From: Amanda Scholes
Sent: 09 March 2012 14:20
To: Planning.Responses
Subject: FW: Personal Objection Re ASDA PLANNING CHANGES - 8 Mar 2012

Please could these be attached to FG/16/12 under Consultation Environmental Health. Thanks

Further to your response to the ASDA application on 2nd March, I have received this letter of objection to the proposal, and as you can see, on the attachment, the objector specifically asks a question on the air conditioning. I would be grateful if you could email your response to his views so that I can incorporate them into my report that I am currently writing.

Proposed Roof Plan

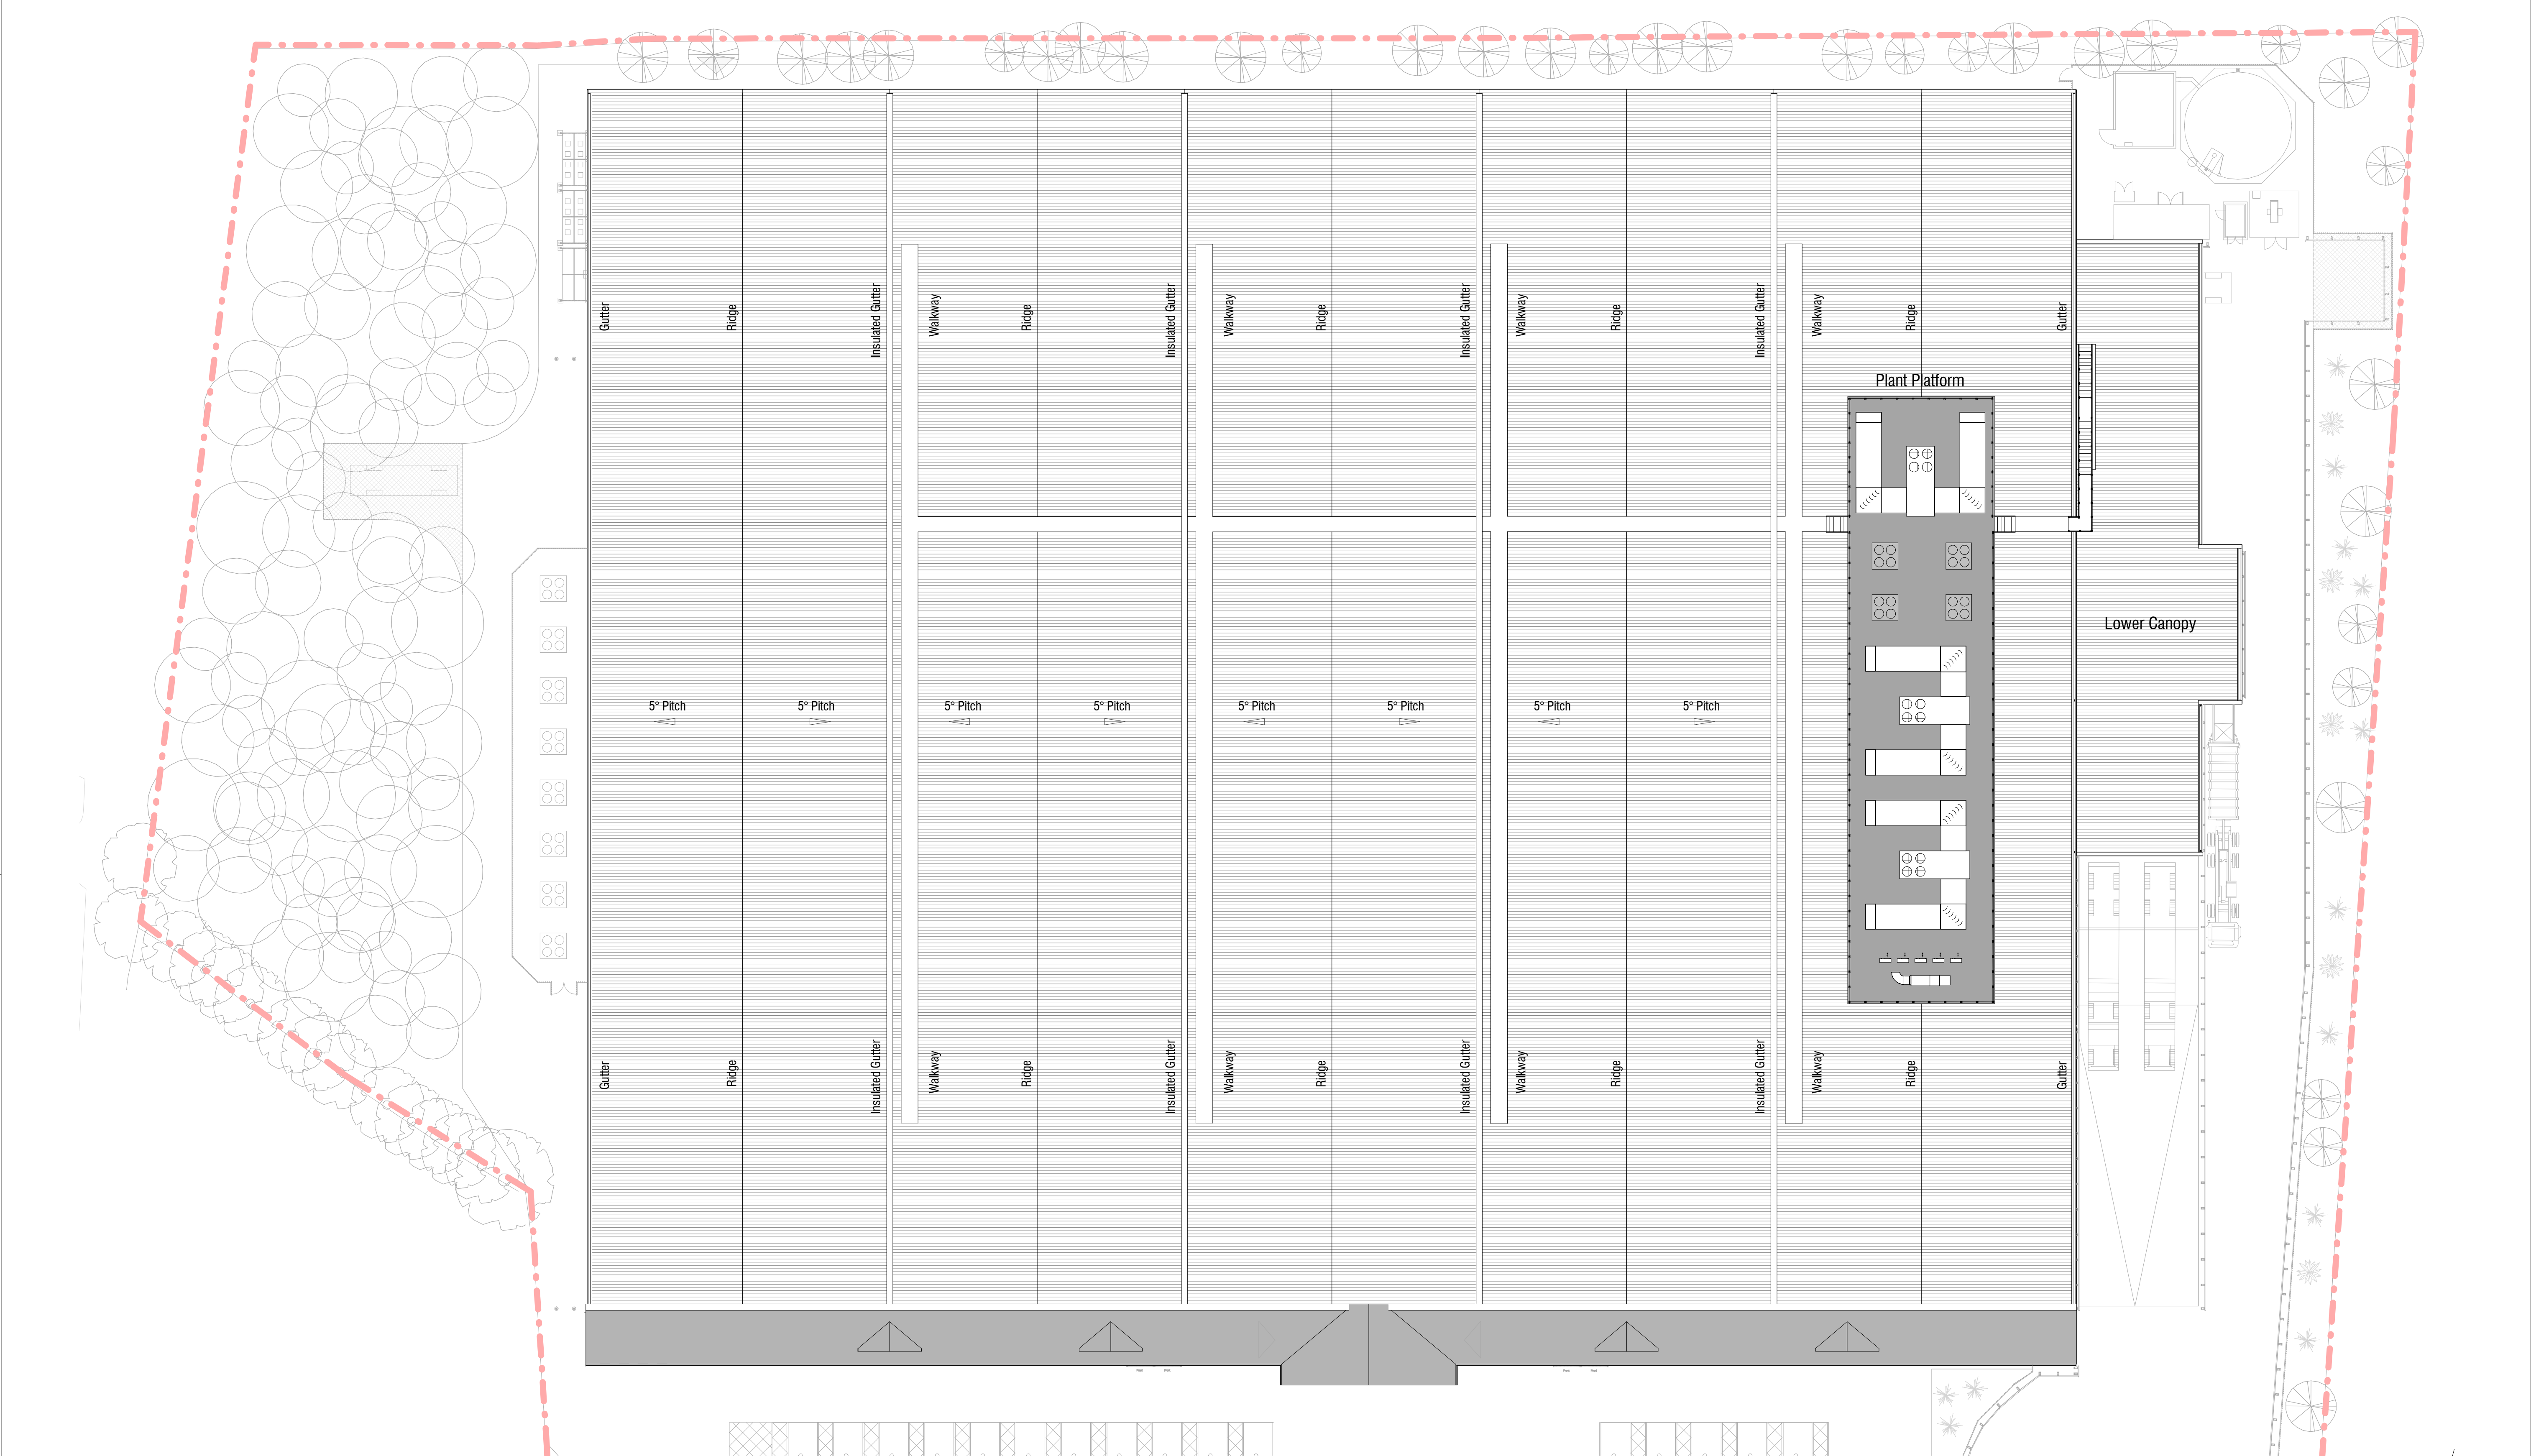
Further to our conversation I can confirm that I am unable to comment without details of noise produced by the plant, ideally a noise consultants report should be obtained to ascertain the impact of noise produced by the plant on existing background noise levels at existing and potential future noise sensitive development. It is likely that significant impact may be mitigated by selection of quiet plant and provision of acoustic screening or enclosures if appropriate.

Furthermore, your earlier comments talked about possible future residential development which may be closer to the AC units. There is an adjoining site (Jenkins Yard) which abuts the ASDA site for 39 dwellings. It has been allowed on appeal, but Arun are challenging the decision.

If Arun were to loose the challenge and the dwellings got approval, what measures would need to be put in place to prevent a noise nuisance on those properties?
